CHERWELL DISTRICT COUNCIL

Representations on Appellant's Revised Unilateral Undertaking and Recommended Conditions

Appellant	:	Gladman Developments
Appeal Site	:	OS Parcels 6741 And 5426 on land west of Cricket Field, north of Wykham Lane, Bodicote
Appellant's Agent	:	N/A
LPA Reference	:	15/01326/OUT
PINS Reference	:	APP/C3105/W/17/3172731

Plan 2 - Drawing Number SK201-01-P3

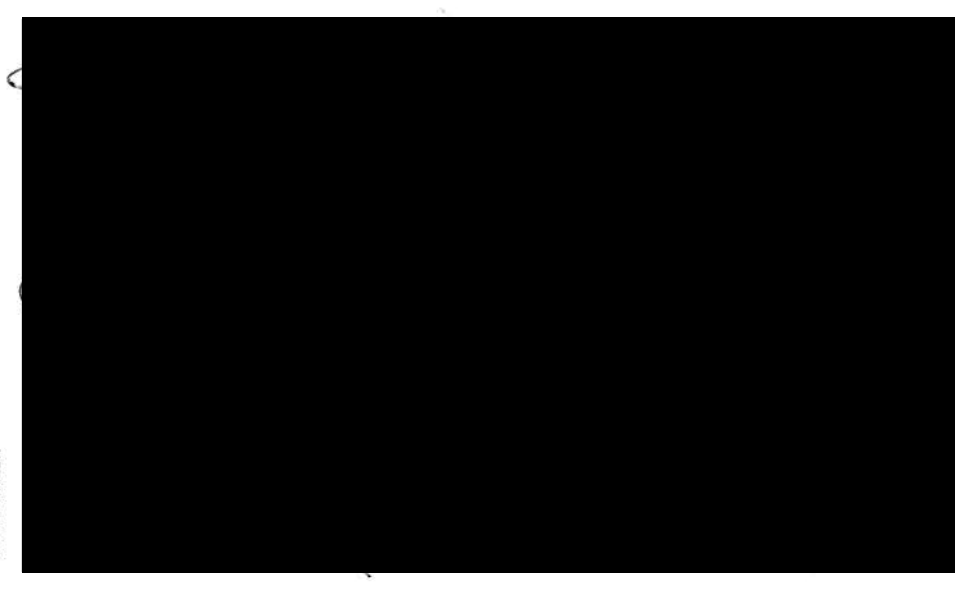
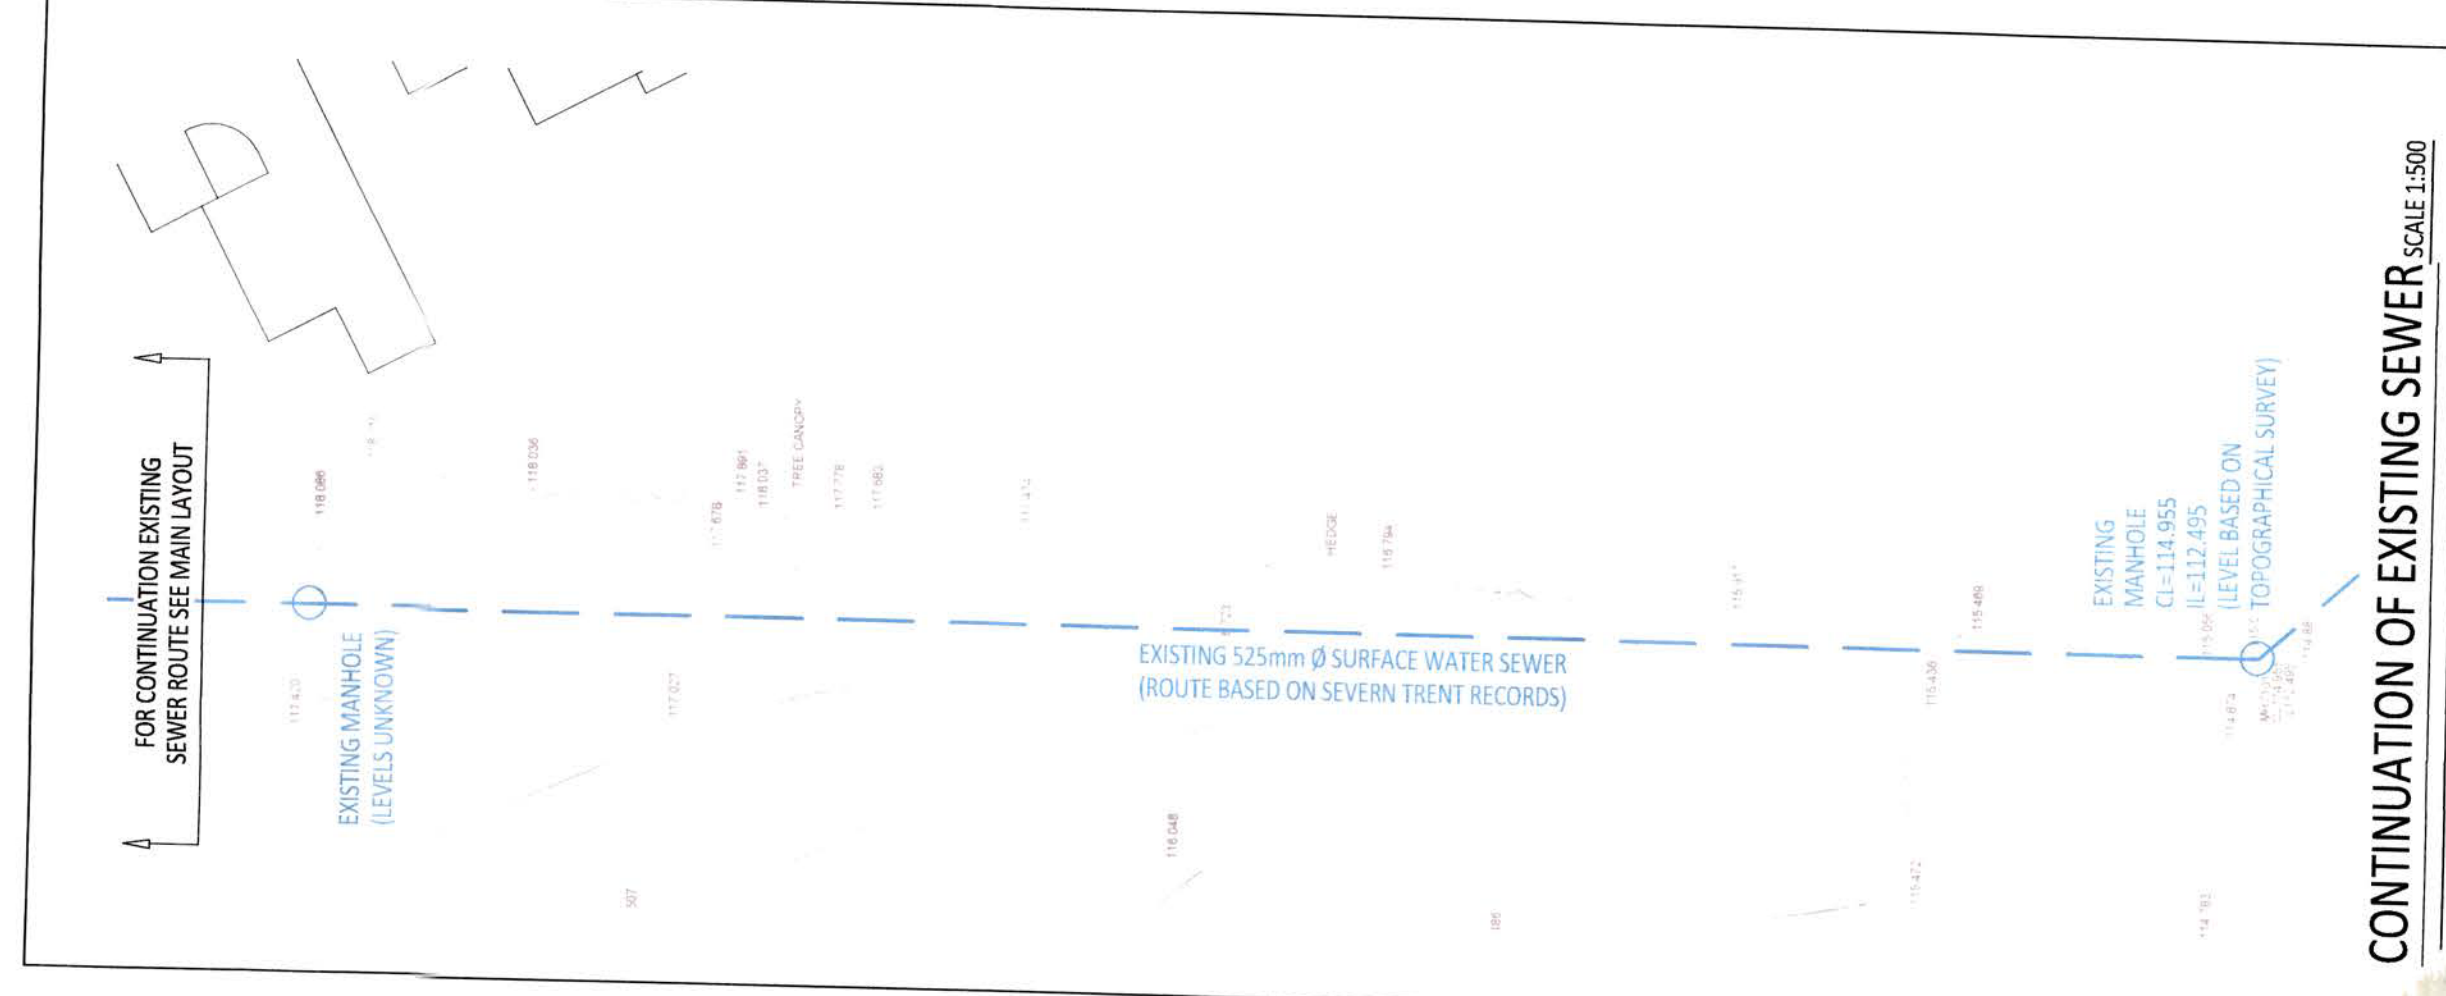
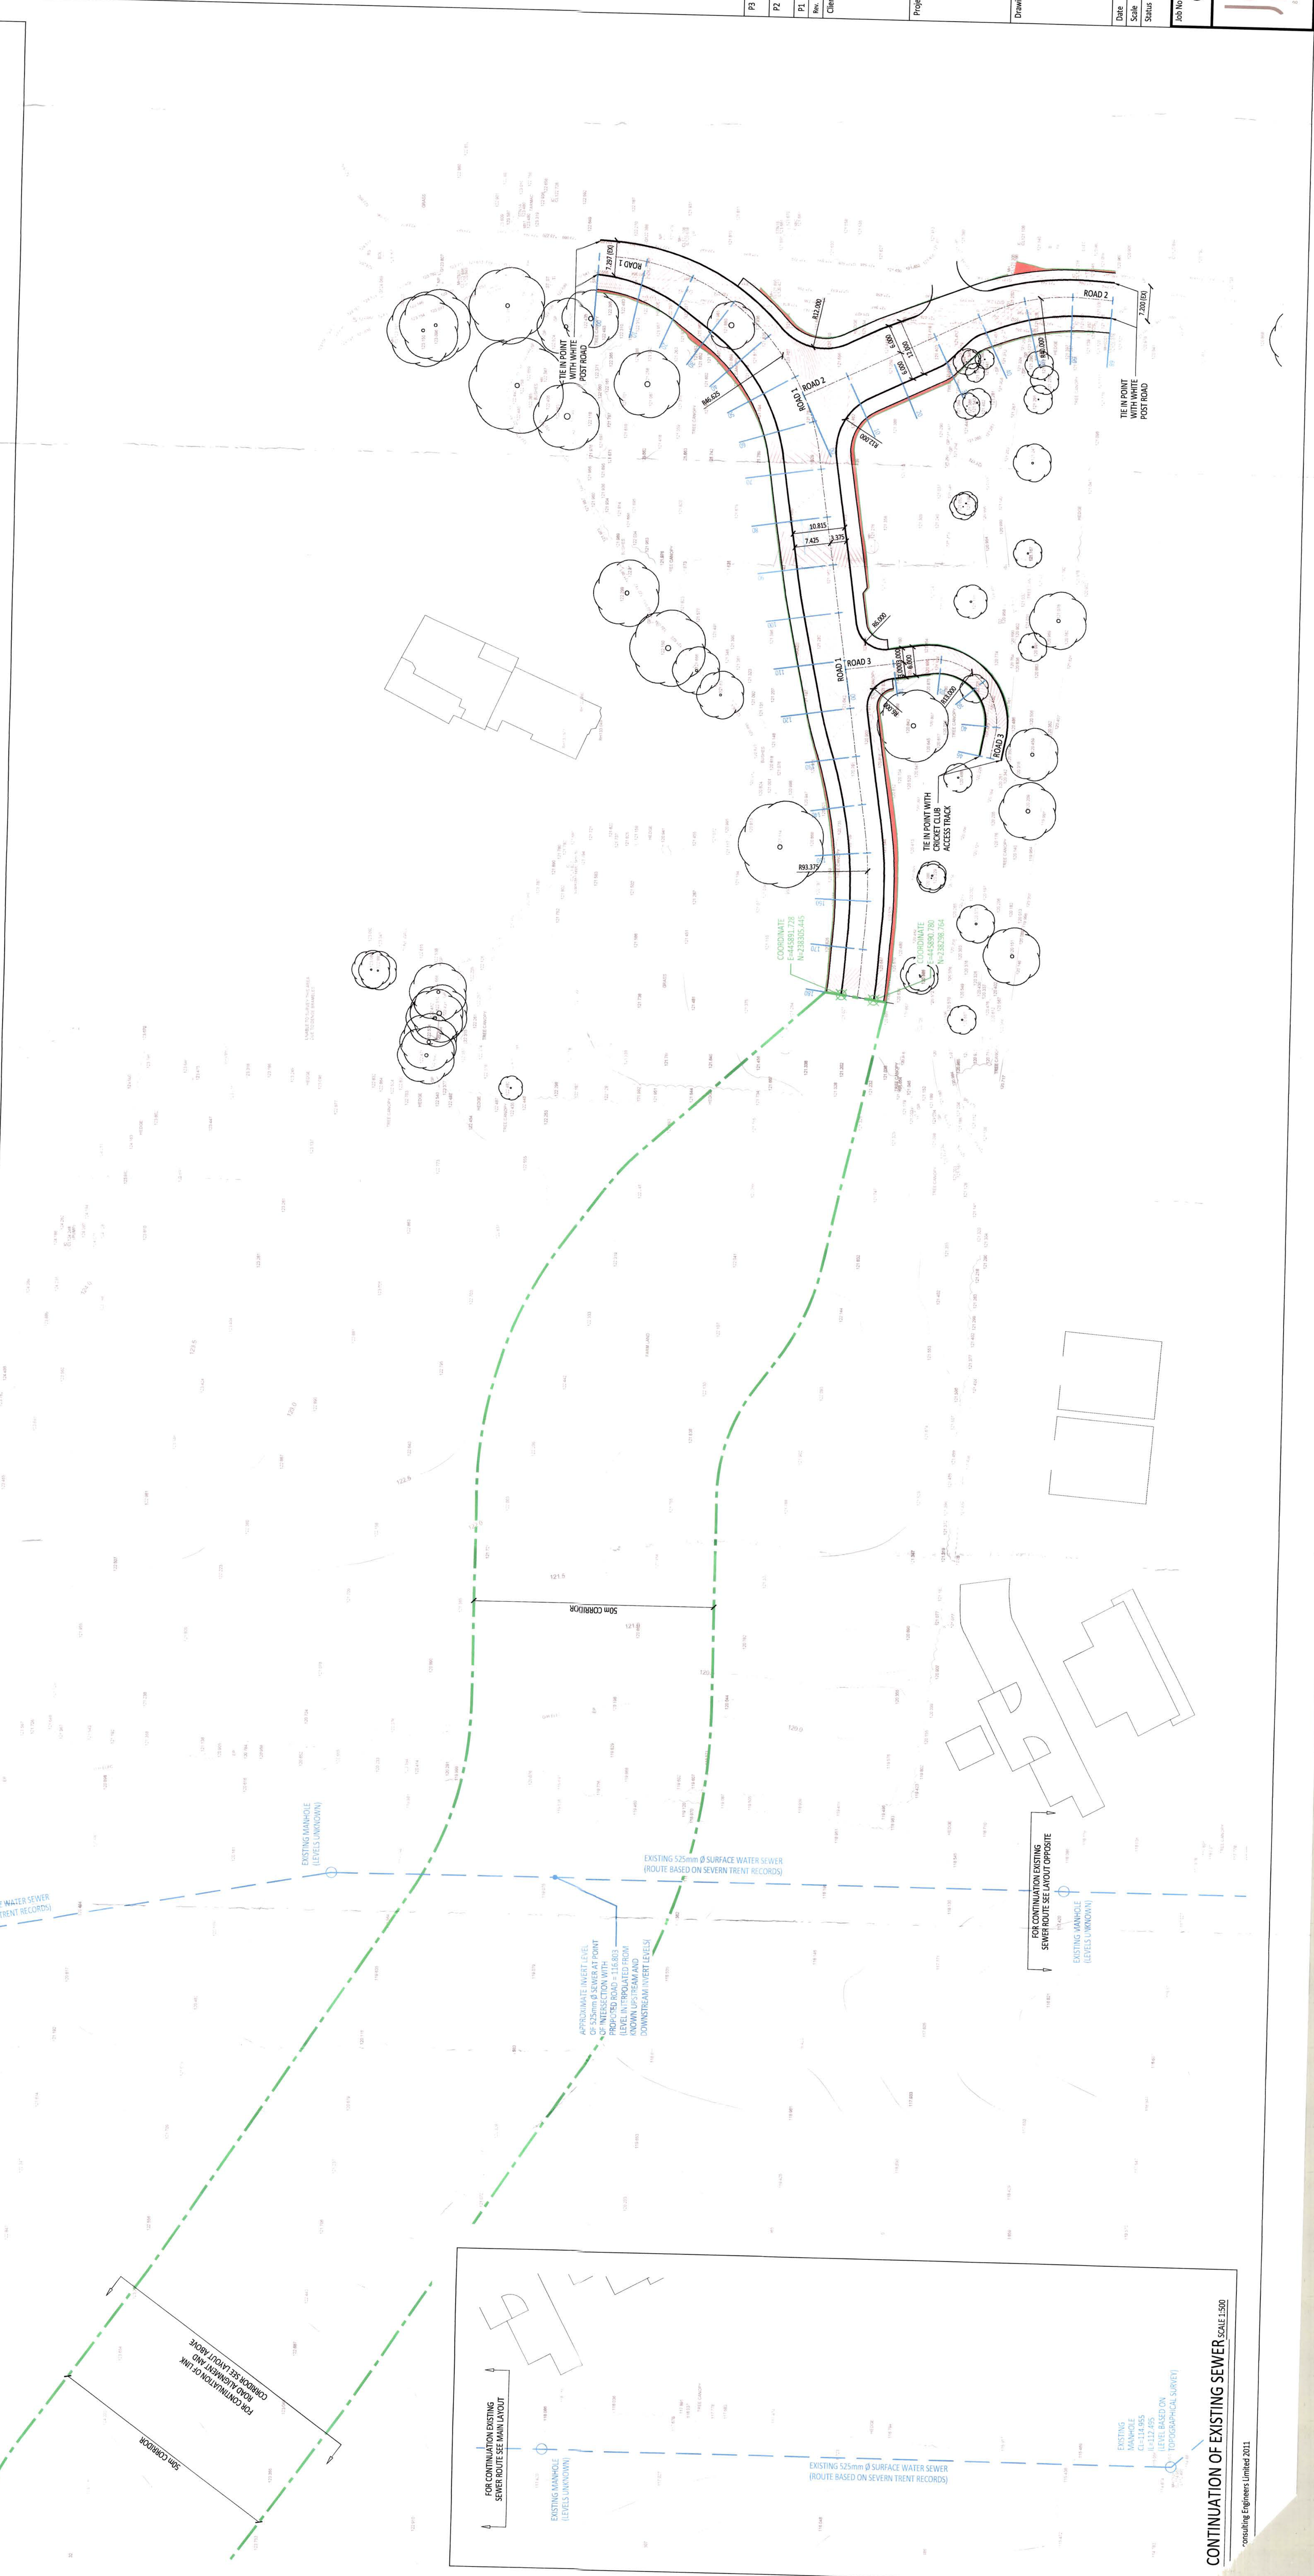
7 – No objection but concern about the appropriateness of referencing what is a separate Unilateral Undertaking within a condition. A planning permission should be able to be understood on its face without having to refer to other legal agreements. This wording *“to the coordinates agreed within Annex 2 of the Unilateral Undertaking”* should therefore not be included within the condition in the Council’s view.
